RE: **Lot 21 Block 1 Volcano Cliffs SAD 227**
6905 Rimrock NW
Grading and Drainage Plan
Engineers Stamp Date 6/15/17 (D10D003D008)

Based upon the information provided in your submittal received 6/21/17, this plan is cannot be approved for Grading Permit until the following comments are addressed.

| | GRADING AND DRAINAGE PLAN | DATE 6-14-17 |

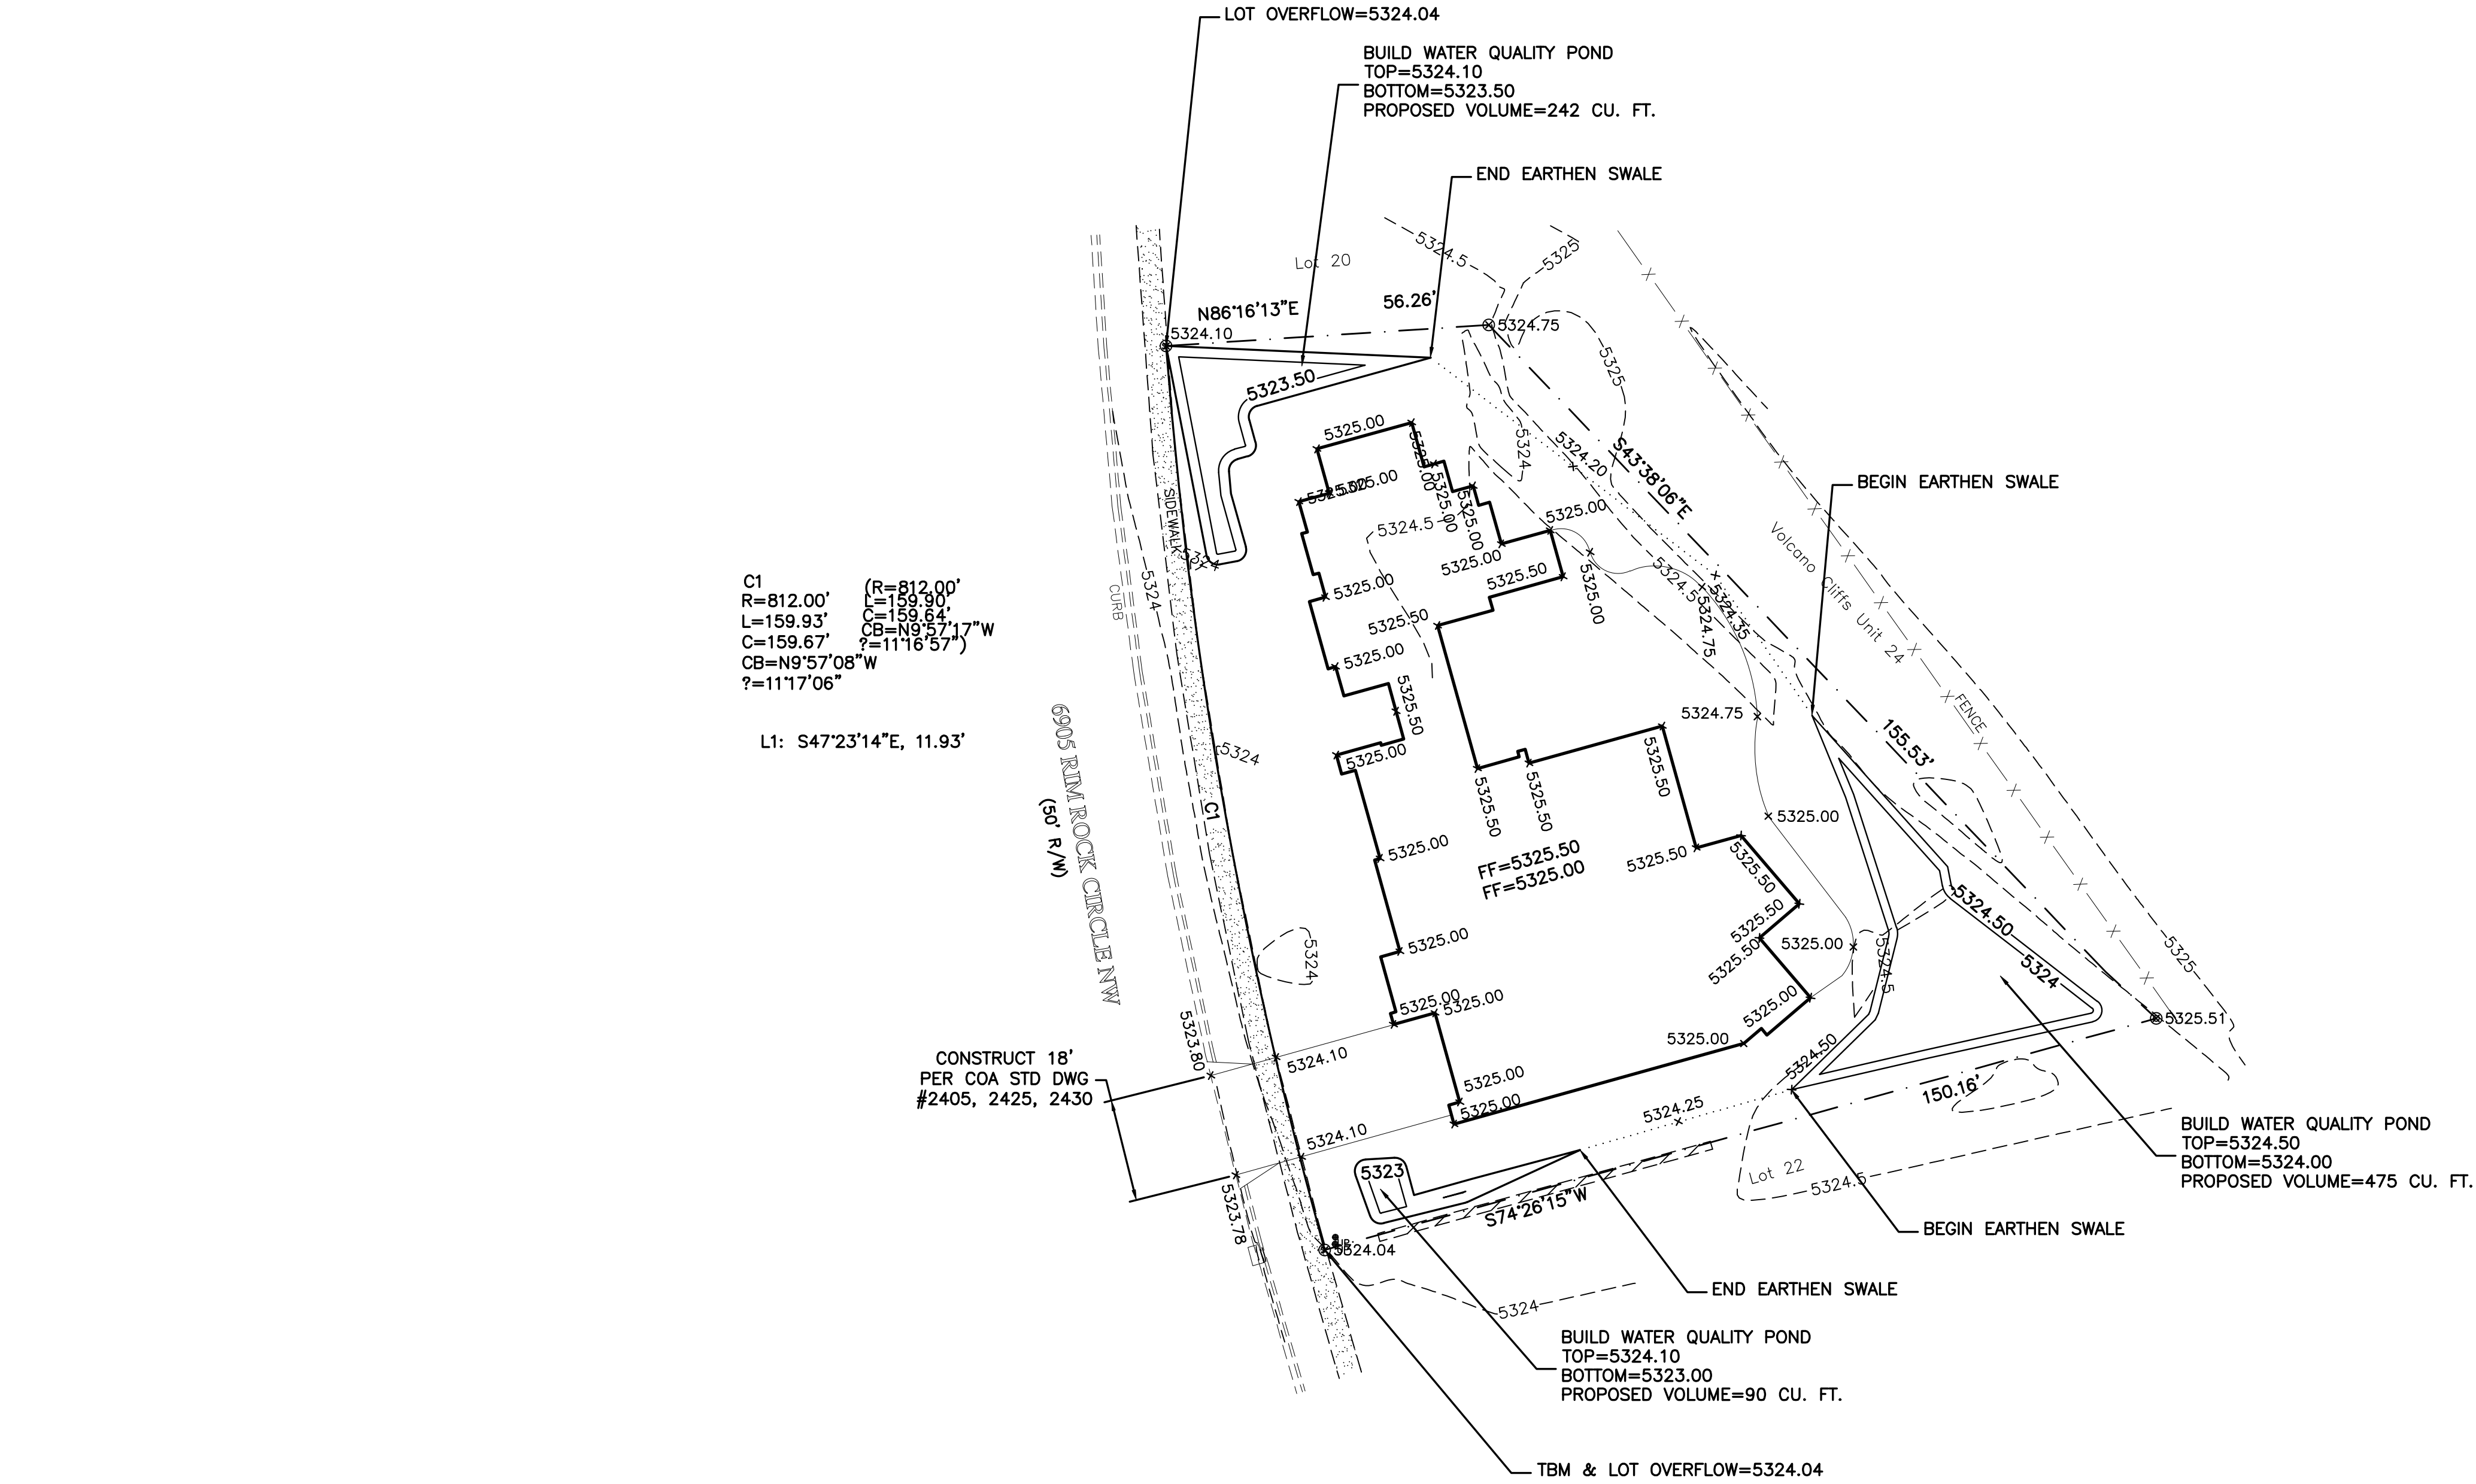
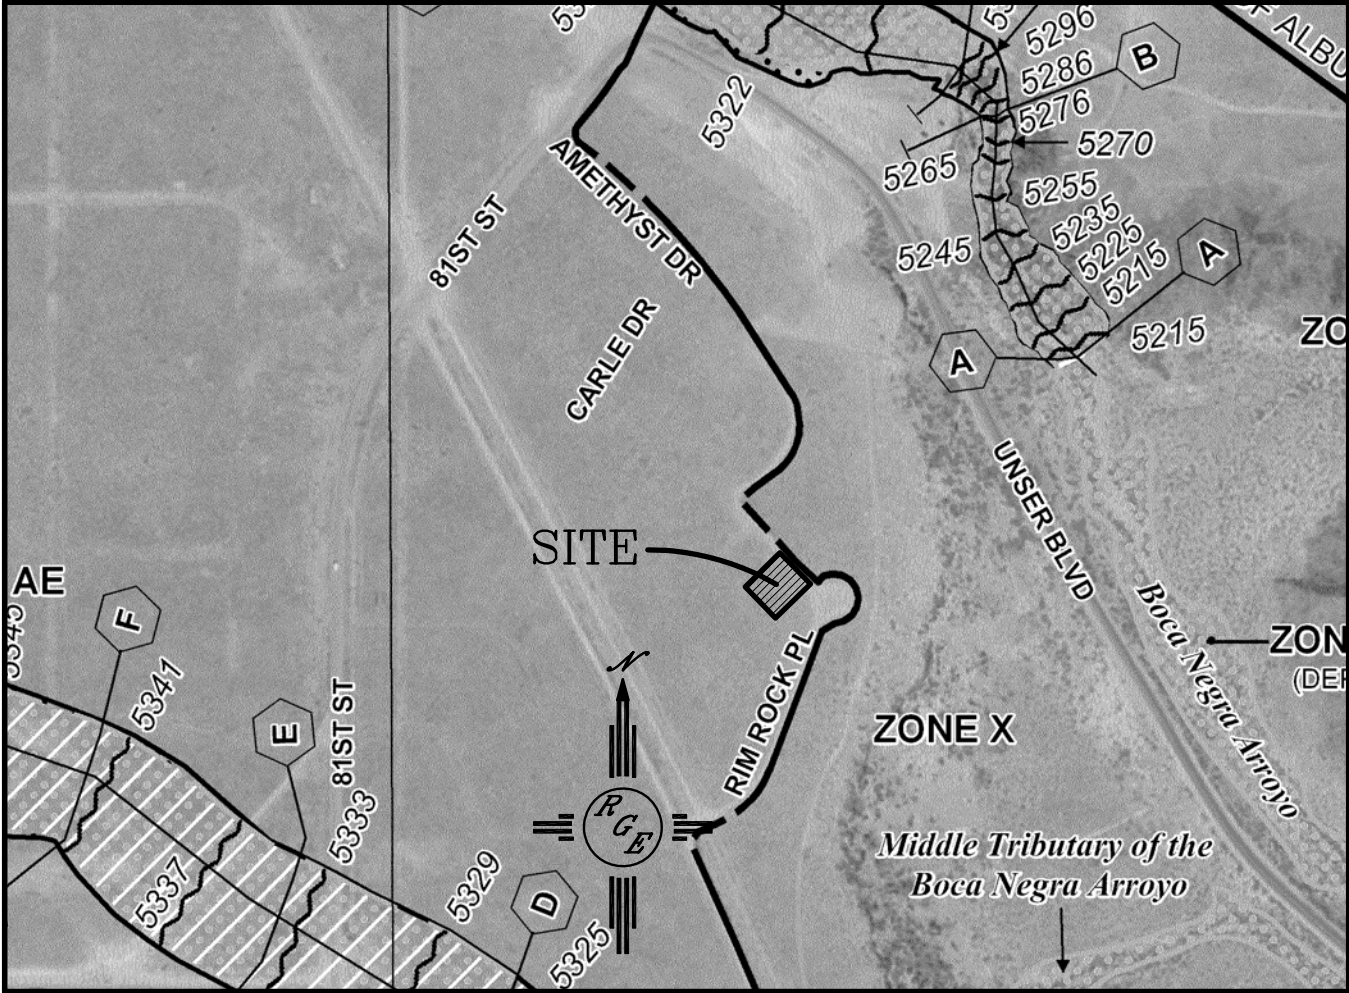
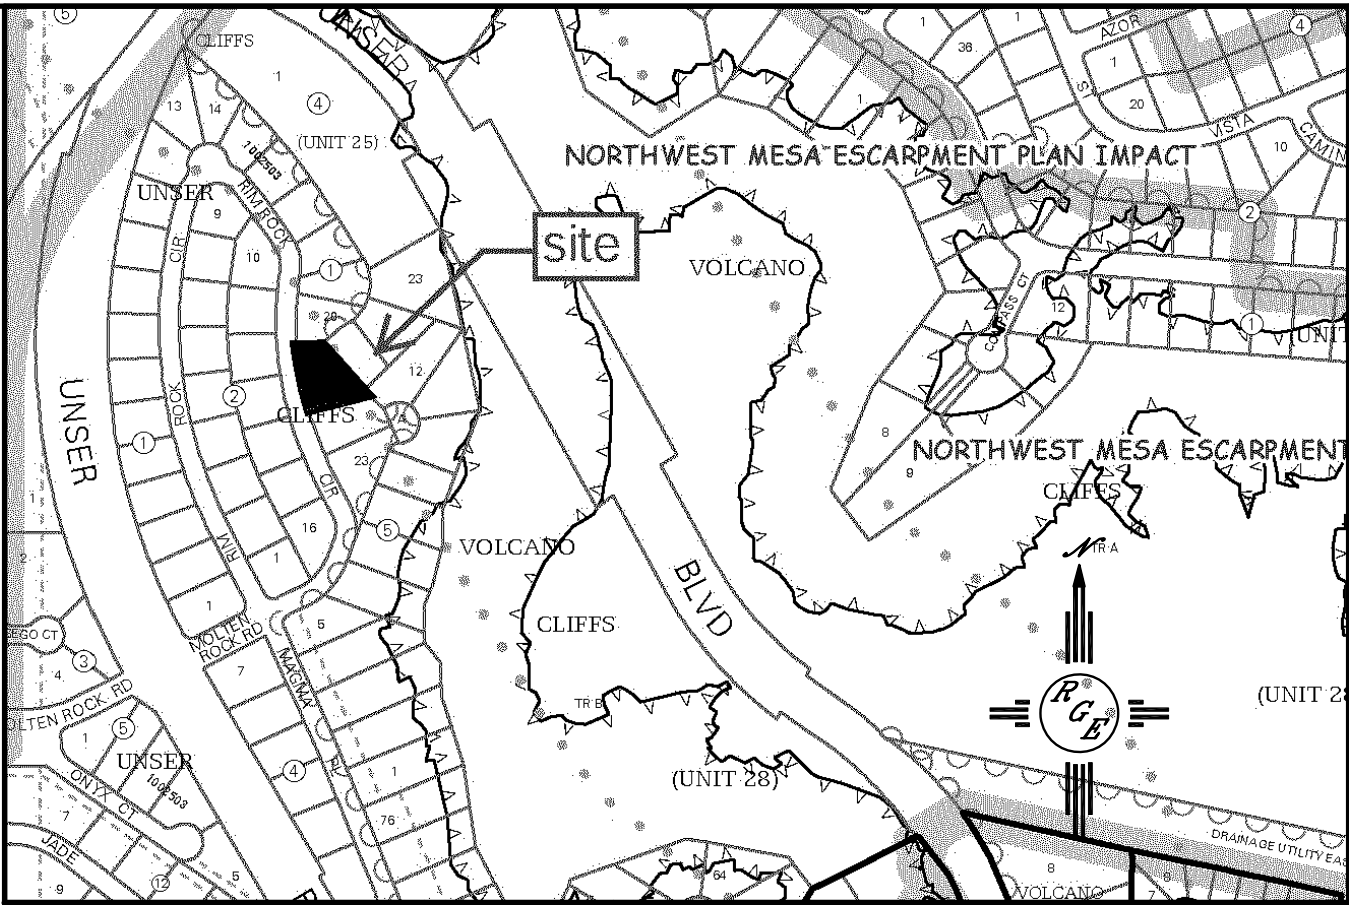
- Provide a statement on the plan that this grading plan must be used for the application of any garden/retaining walls.
- Provide a statement that a Pad Certification is required before building permit can be approved.
